THE ABLE MARINE ENERGY PARK DEVELOPMENT CONSENT ORDER

TR030001

**Comments by the Harbour Master, Humber on the
revised draft Order dated 9 October 2012**

Unique Reference Number	URN 10015524
Rule No.	17
Document Ref.	CO9.10
Author	Harbour Master, Humber
Date	30 October 2012
Date of revision and version number	1.0

Figure 7: Proposed Monitoring Buoy Location

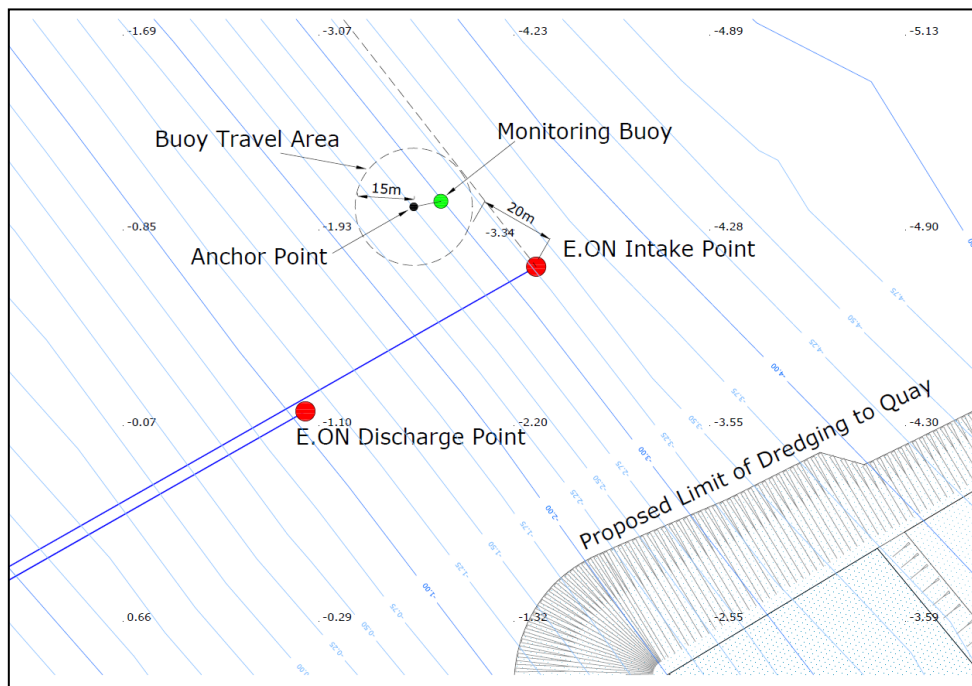
40. In paragraph 13, "mitigation" needs to be amended to "monitoring".
41. The active monitoring scheme required by paragraph 26 will include details of the locations of active monitoring buoys. The placing of buoys is a potential obstruction to navigation. It should be subject to HMH's approval
